Re: Planning Consultation for 59872/APP/2015/665

MEMORANDUM

Ground Floor Plan

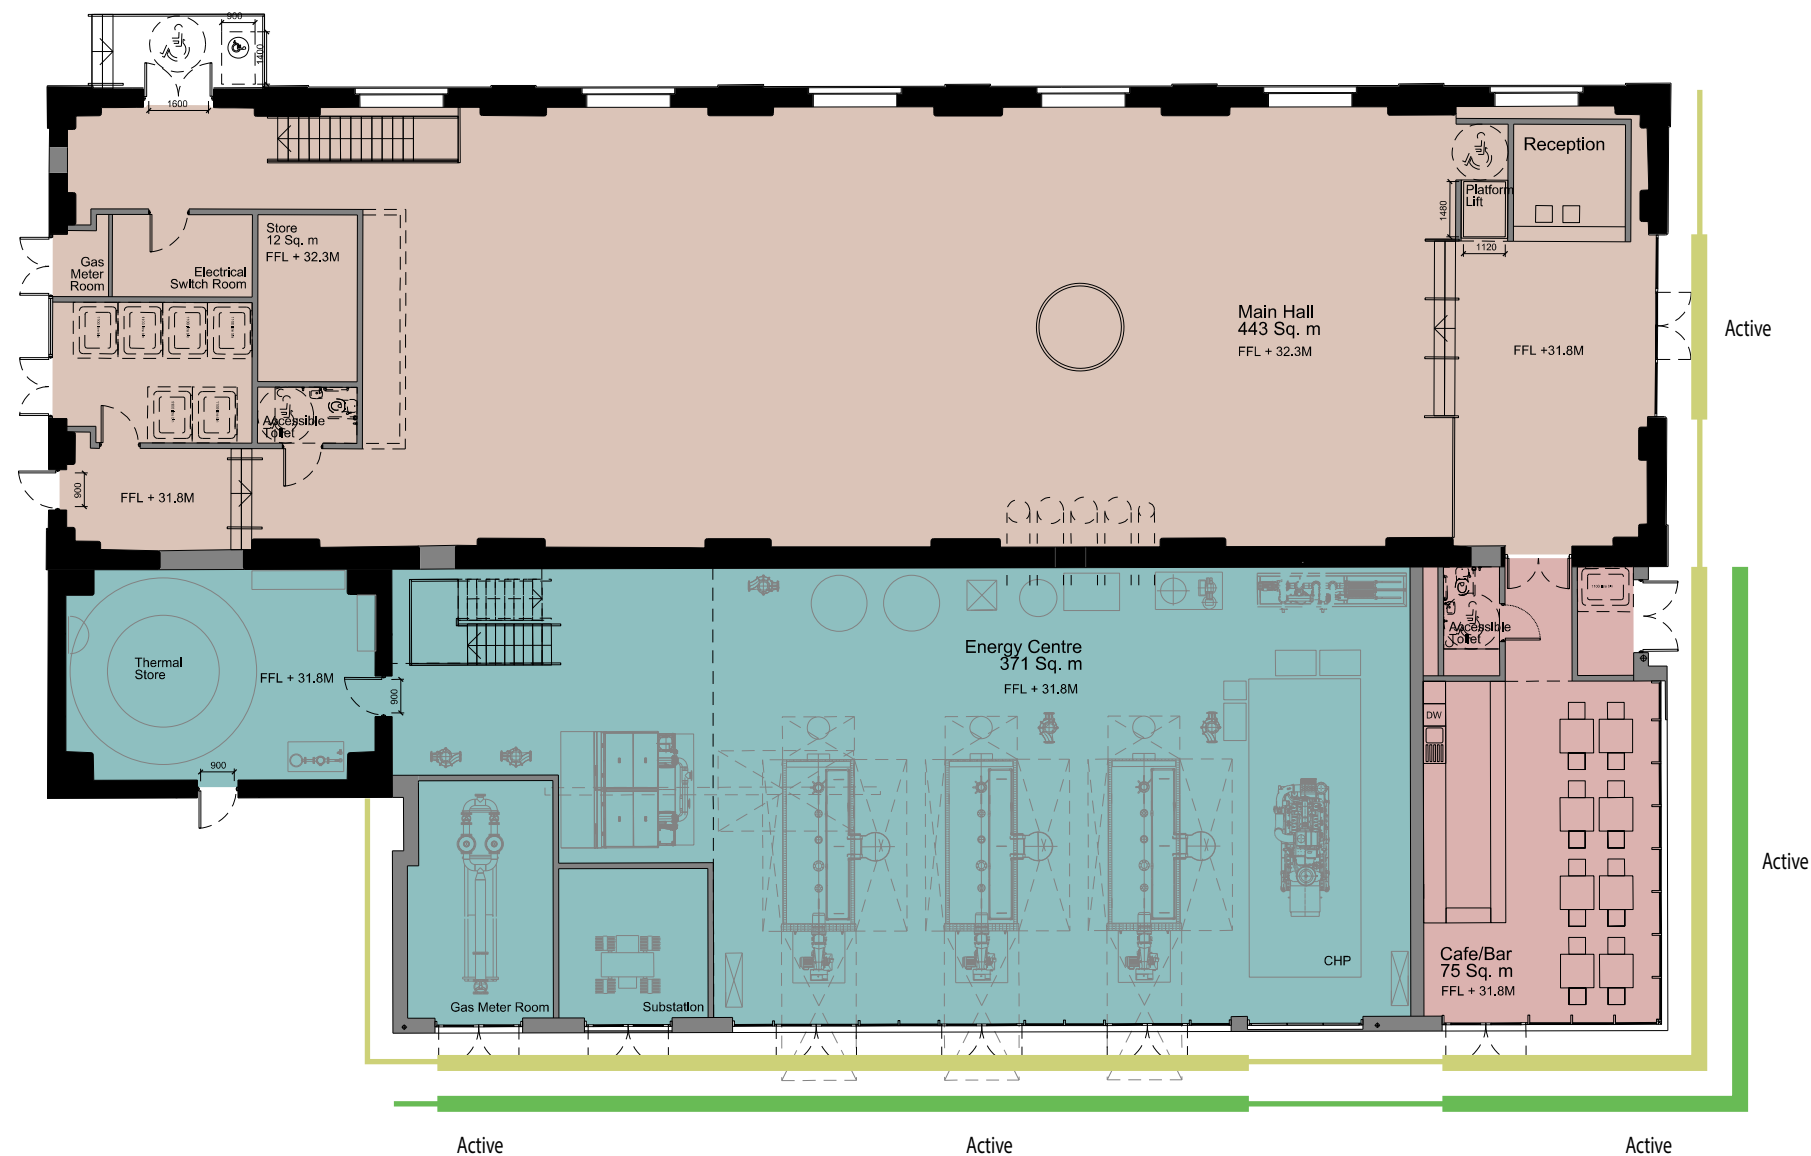
Having looked at the plans I do not agree that only 1 bin is easily accessible. There are two doors into the bin store (one from inside the restaurant/venue) and double doors outside. 3 are very accessible while there is a gap of at least 750mm between the two rows of bins which is surely more than enough for people to walk between them.

I have a concern about the size of the bin chamber and alignment of bins there in.

If the bins were placed as shown on the plan only the bin at the end of the line would be easily accessible. For practicality of use the bins would be better rotated by 90 degrees and have the back of the container (hinge side) against the wall.
